OBJECTION to P/53/19/L

22nd July 2019.

The plan to make the Inglenook Hotel side entrance wider, is a bad plan, making the entrance

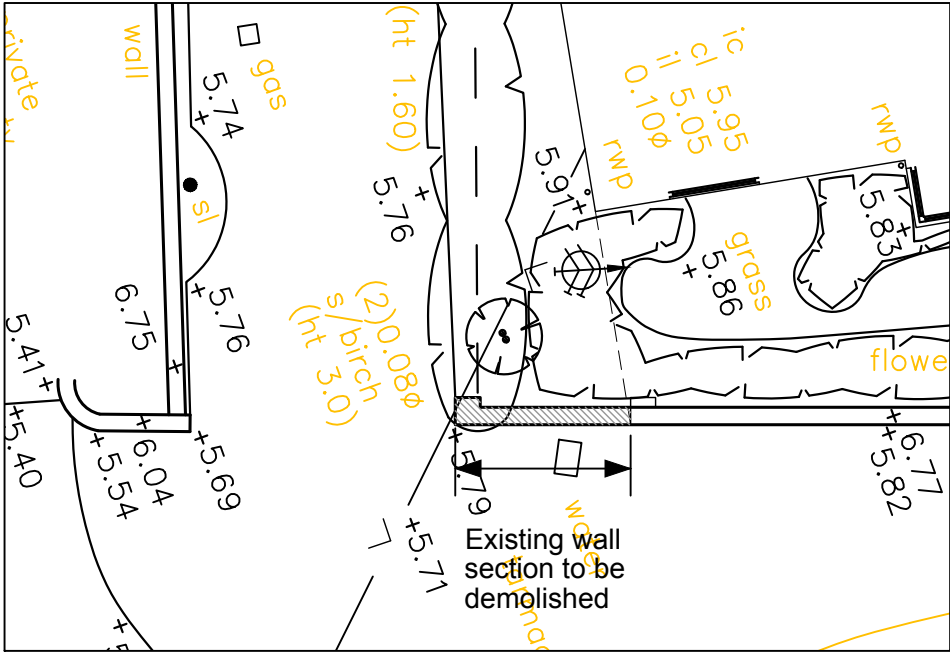
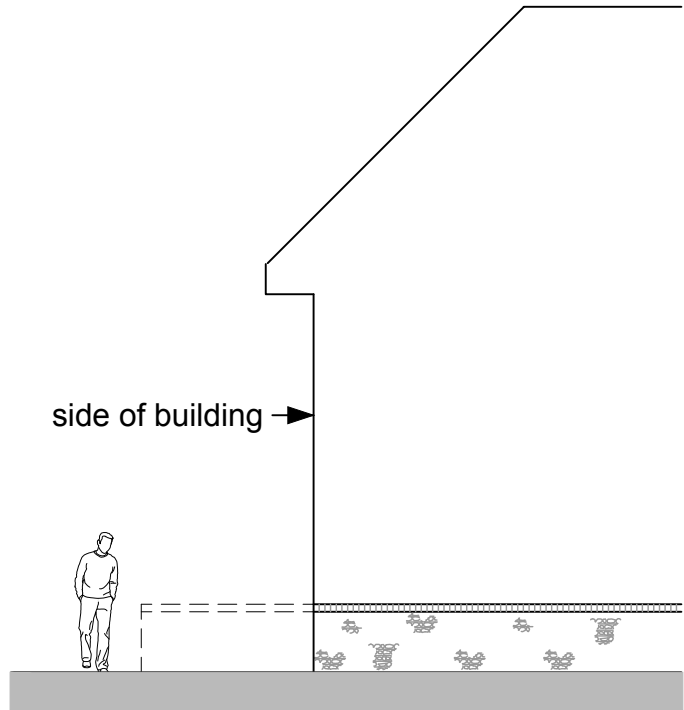
A bit wider will not make the rest of the lane wider; it will have to accommodate, Fire engines,

Ambulances' Enormous refuge Lorries, they would struggle to get down there, if the plan is excepted
